Ref:	Question:	SCC Response:
1.9	<p>Article 13 – Traffic regulation measures With reference to recent DCO precedent, should Article 13(5)(c) be added to ensure adequate notification of the powers under Articles 13(1) and 13(2): “(c) displayed a site notice containing the same information at each end of the length of road affected”?</p>	<p>We are content with the proposed amendment.</p>

Figure 10.2: SCENARIO 1 PREFERRED CONSTRUCTION VEHICLE ROUTING

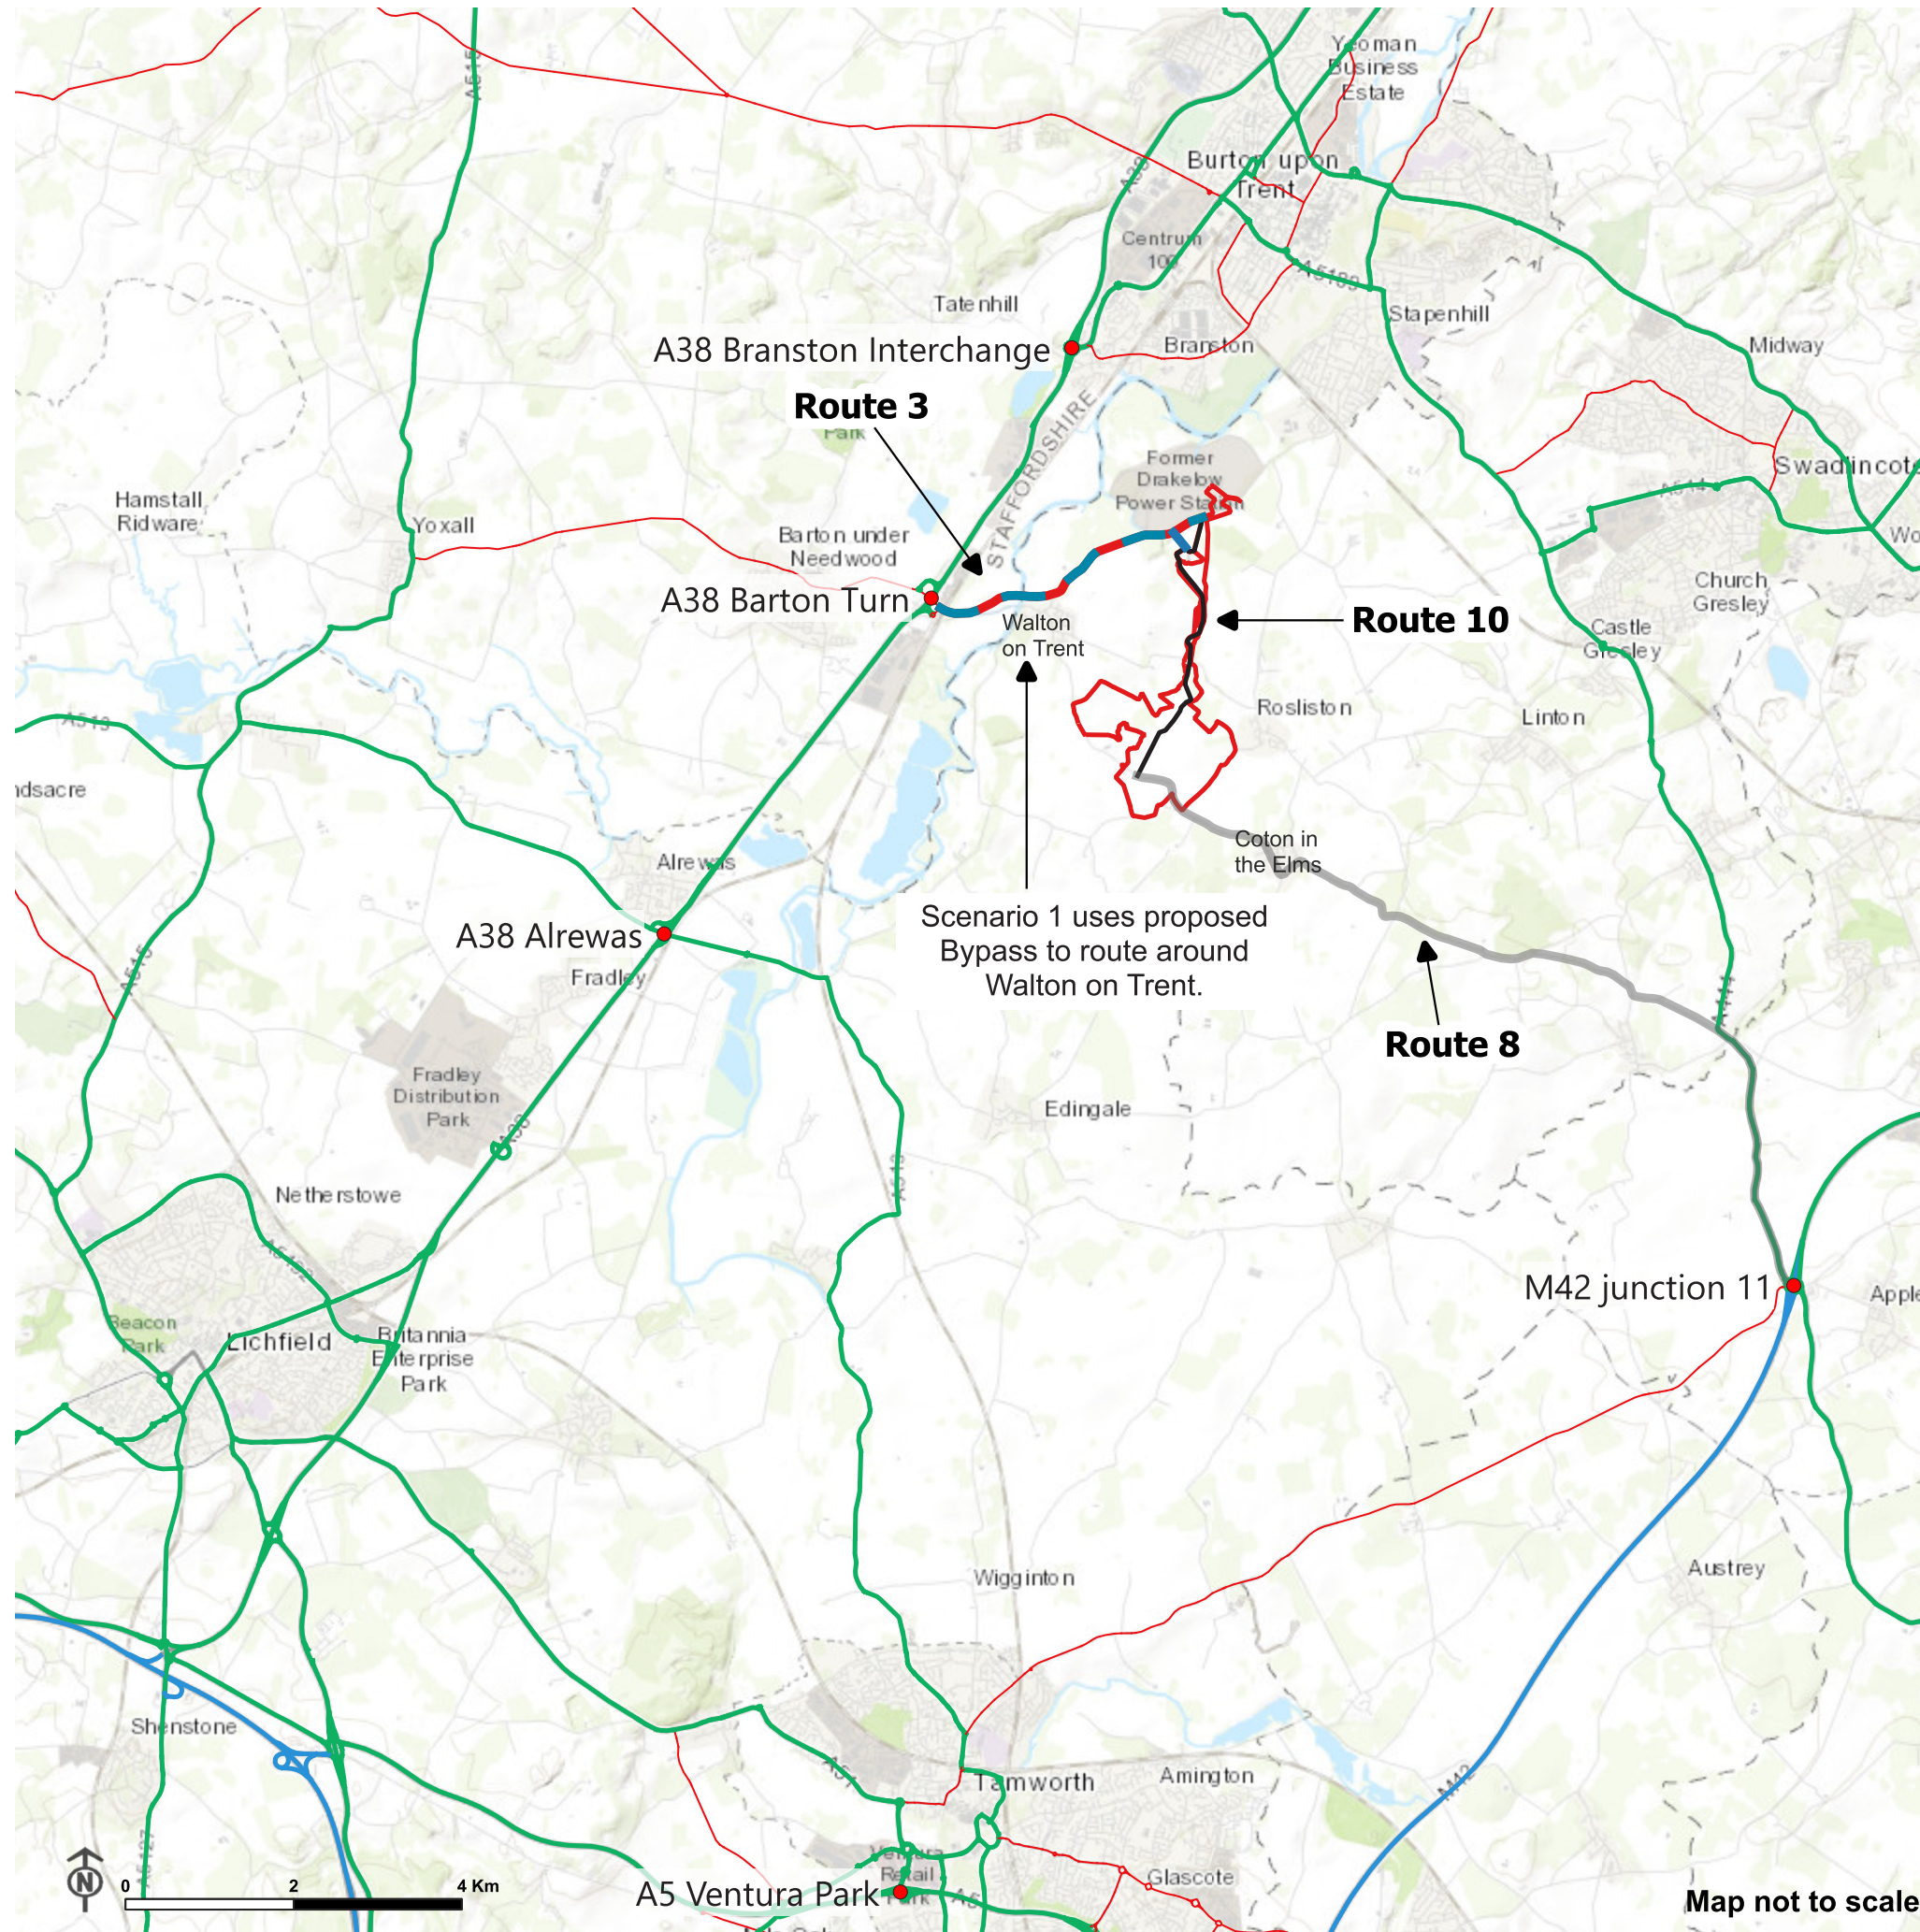
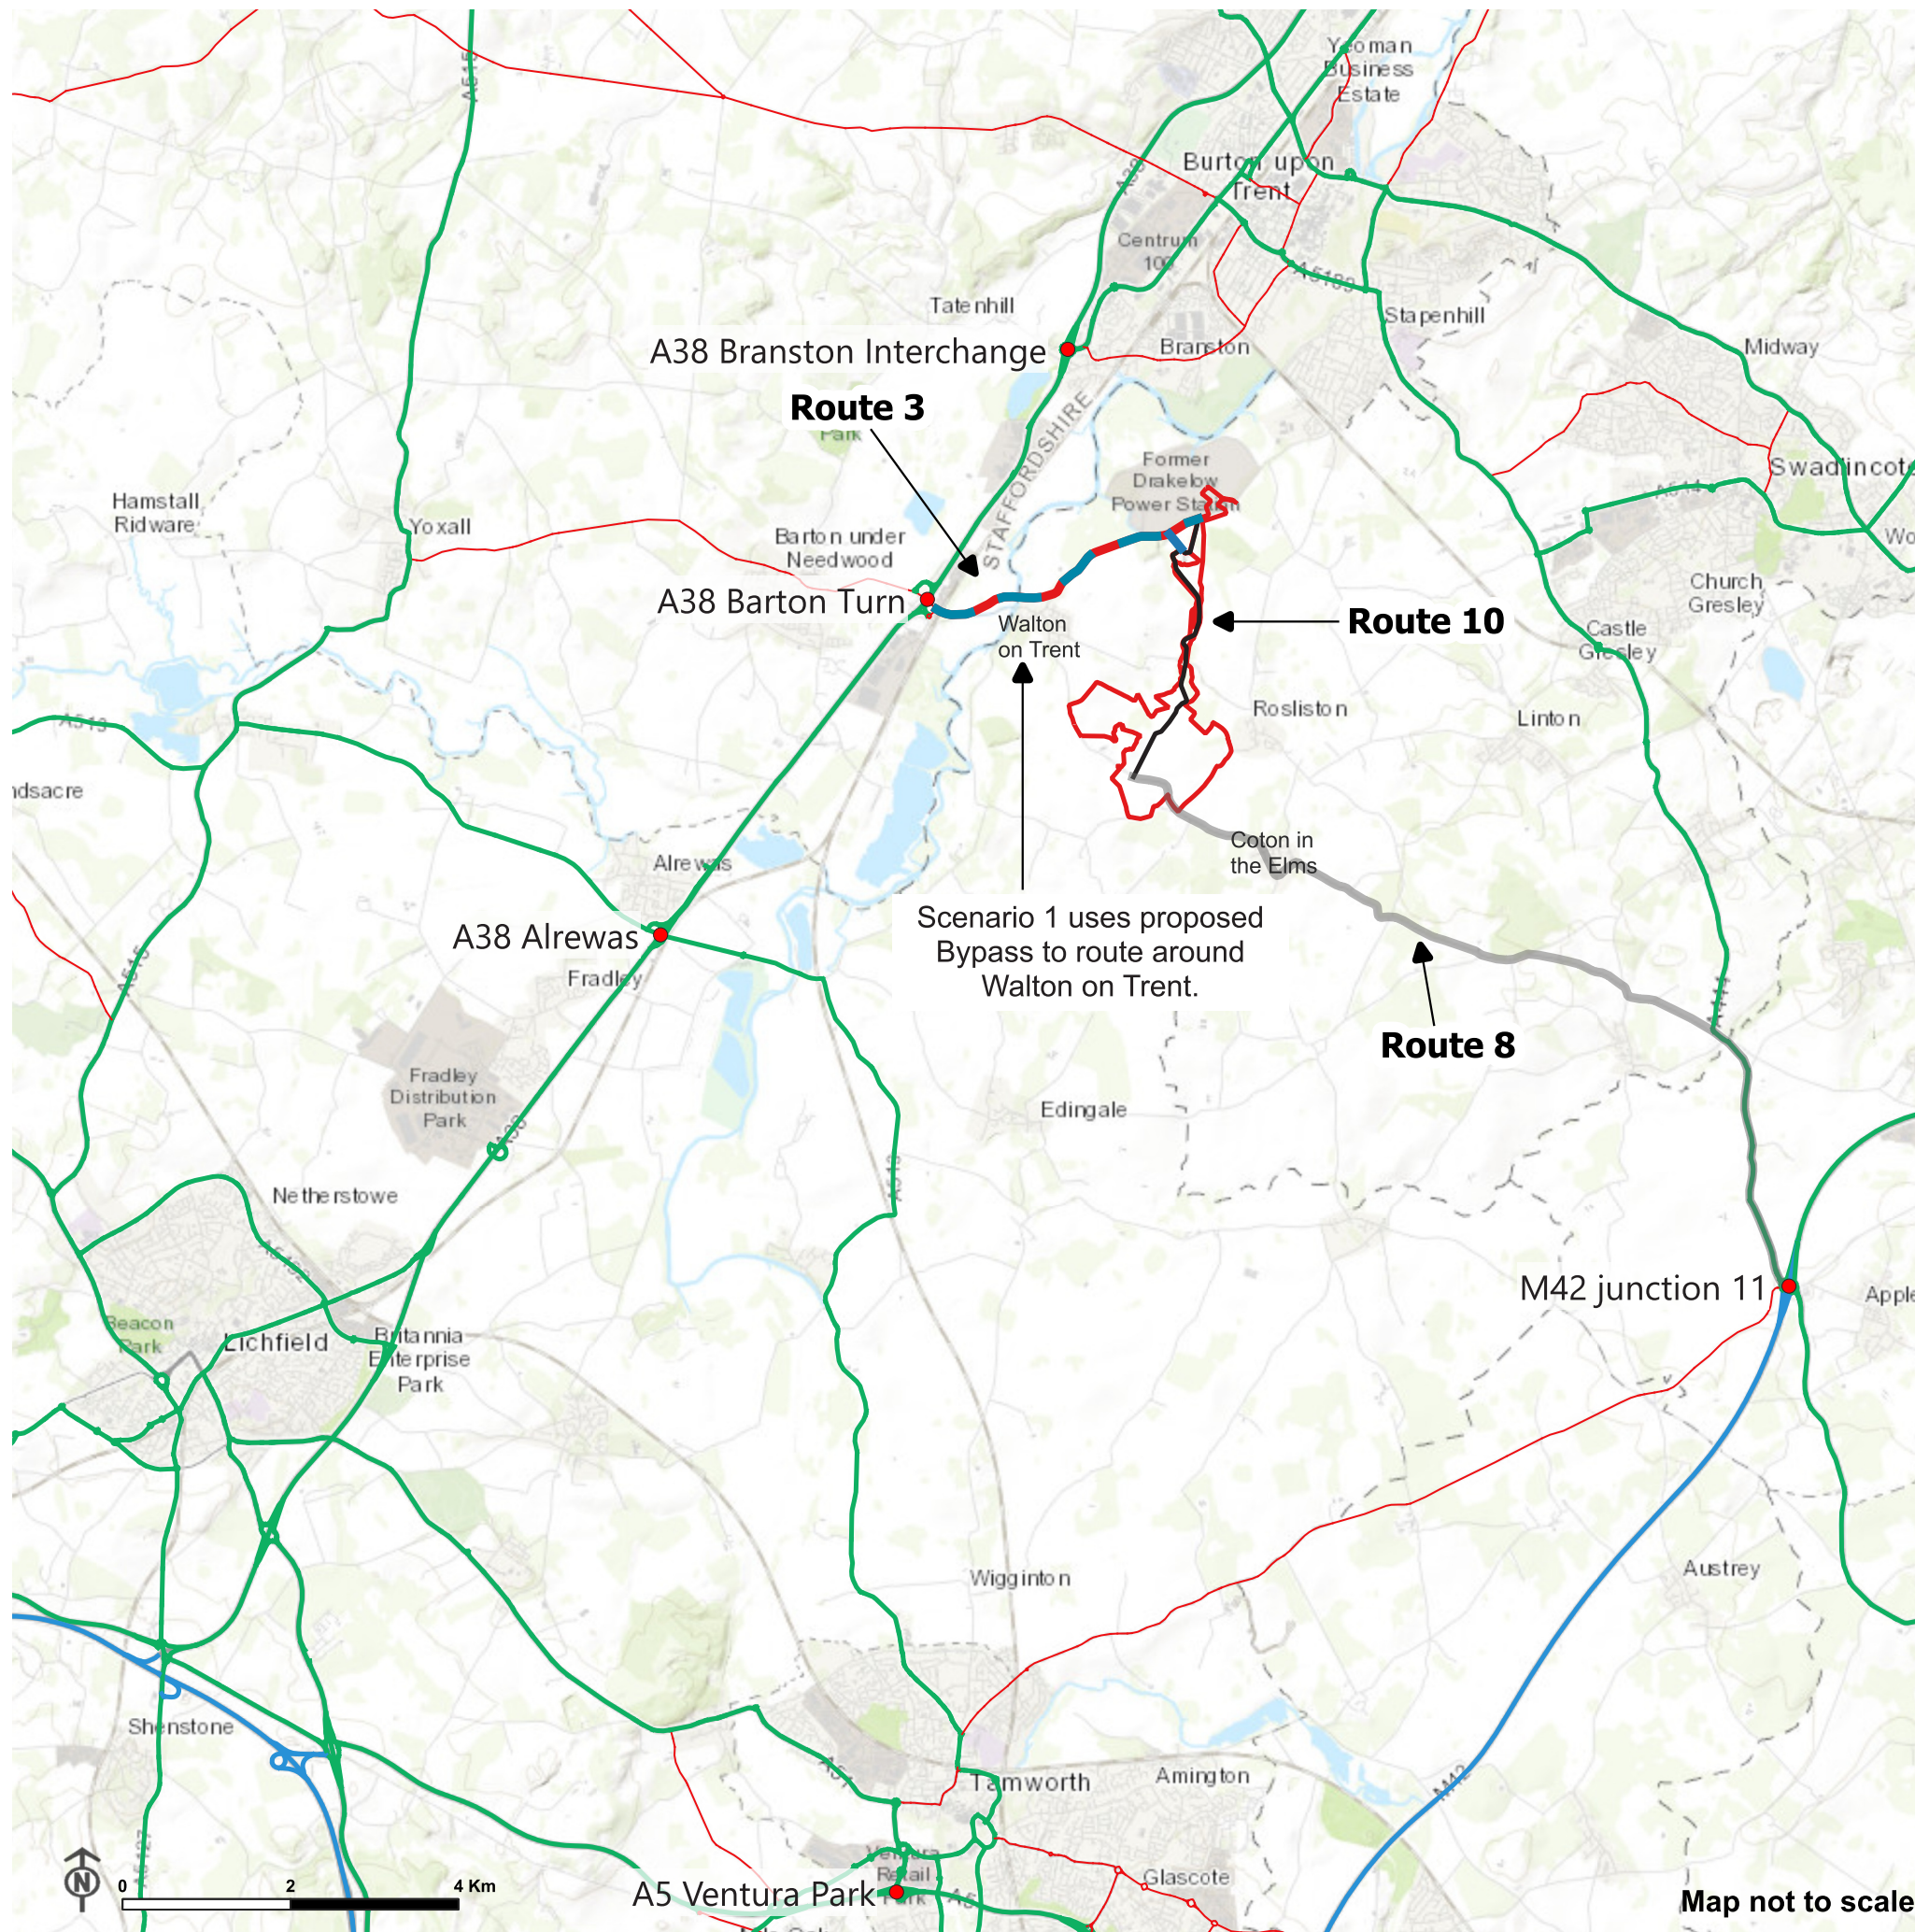
11.2	<p>Securing the construction traffic routes</p> <p>The Applicant [REP1-025 response to question 11.4] says that subject to responses from others, it is content to amend the Outline CTMP [REP1-009] to secure that:</p> <ul style="list-style-type: none"> • construction route Scenario 2A to only be used if Scenario 1 (using Walton-on-Trent bypass) is not available; and • construction route Scenario 2B to only be used if Scenarios 1 and 2A are not available. <p>a) Are DCC, SDDC, or SCC content for the Outline CTMP [REP1-009] to be updated to secure the above?</p> <p>b) Please could the Applicant, following discussion with DCC, SDDC, and SCC, update the Outline CTMP [REP1-009] accordingly?</p>	<p>a) We are content with the first bullet point. However, in relation to the second bullet point we have an outstanding matter raised in relation as to why routes 2A and 2B cannot be used in conjunction with one another if route 1 is not available (see Q11.4). For example Route 2A will not be available during the afternoon school run period and potentially for a period overlapping the AM network peak hour. It is our understanding that assessment has only been undertaken to compare each route being used in isolation and not whether impacts could be further lessened by spreading the load over two routes should the preferred scenario 1 be unavailable.</p> <p>The OCTMP can only be agreed when the issue has been resolved. Should the ExA determine routes 2A and 2B should be kept separate then the wording proposed in the OCTMP as set out in the two bullet point is acceptable.</p>

11.4	<p>Construction traffic – SCC concerns</p> <p>SCC [REP1-031] raise concerns including in relation to:</p> <ul style="list-style-type: none"> • why routes 2A and 2B could not be used in conjunction with one another to spread the impacts of construction traffic across the network rather than focussing it on a particular route; • consideration to the movement of young pedestrians who would potentially need to cross and/ or walk along the construction traffic route on their way to/from school 	<p>We have been in discussions with the Applicant post our deadline 1 submission and understand a revised OCTMP will be submitted at Deadline 4. We are mindful of making substantive comments on a document that has yet to be seen by the ExA at this juncture for the risk of causing confusion. However, the revised OCTMP we have seen should address a number of the points we raised, including relation to schools along the construction traffic route 2A by restricting movements during the school run.</p>

<p>for which the Outline CTMP [REP1-021] should restrict the movement of HGV traffic on route 6 during the morning and afternoon school runs during term time;</p> <ul style="list-style-type: none">• whether the construction of the Drakelow Park development has been accounted for in the impacts of construction traffic;• the consideration given to potential delays at a narrow bridge on Rosliston Road over the railway as construction traffic Route 6 enters Derbyshire;• potential impacts from construction traffic not using prescribed construction routes;• it is not clear whether the dDCO [REP3-008] provides for works to remedy any damage caused and attributable to the solar farm development to be undertaken by the developer or whether there are powers for the local highway authority to agree the detail of the works and approve the workmanship of any work undertaken; and• the Outline CTMP [REP1-021] include provision for recouping of and costs incurred by the local highway authority in undertaking emergency repair work of damage caused by construction traffic. <p>The Applicant's responses [REP3-031] include that during pre-application it was agreed with DCC and SCC that a hierarchy of routes would be supported for HGV, whereas for lighter construction vehicles it was agreed the dispersion of these lighter vehicles across the network would be acceptable;</p> <ul style="list-style-type: none">• paragraph 5.5 of the Outline CTMP [REP1-021] has been amended to require all HGV movements to occur	<p>The principal points of objection likely to remain are:</p> <ol style="list-style-type: none">1. Provisions for the highway authority to recoup costs and/or approve remedial works to the construction traffic route. The OCTMP can set out the basis for how this could take place. However, the DCO does not contain the relevant powers to deliver. Therefore, we suggest a Development Consent Obligation (S106) is required to set out the obligations between the parties and mechanisms for payments to be made. The Applicant has suggested such powers exist in S59 of the Highways Act. However, this power is seldom used due to the need to prove damage has been caused in court. Here we have known construction traffic routes that will experience increased HGV traffic therefore specific provisions should be made to address.2. We are not yet convinced the provisions in the OCTMP relating to ensuring compliance with use of the approved construction traffic routes are suitably robust.

<p>outside of the traditional local highway network peak periods, including School Drop off (08:30-09:30) and School Pick up (15:00-16:00);</p> <ul style="list-style-type: none">• Drakelow Park is currently being built out and construction traffic has been captured in the baseline traffic surveys that were undertaken in 2022;• the average of 14 HGV movements per day with restrictions to HGV movements to occur outside peak periods mean that there is unlikely to be material delays at the railway bridge above those occurring within baseline condition; and• the Outline CTMP [REP1-021] requires contractors to use the prescribed construction vehicle routes such as contractual agreements and financial penalties for breaches thereby discourage use of non-prescribed construction routes. <p>a) Please could SCC set out any remaining construction traffic concerns and suggest how their issues might be resolved?</p> <p>b) Please could the Applicant comment?</p>
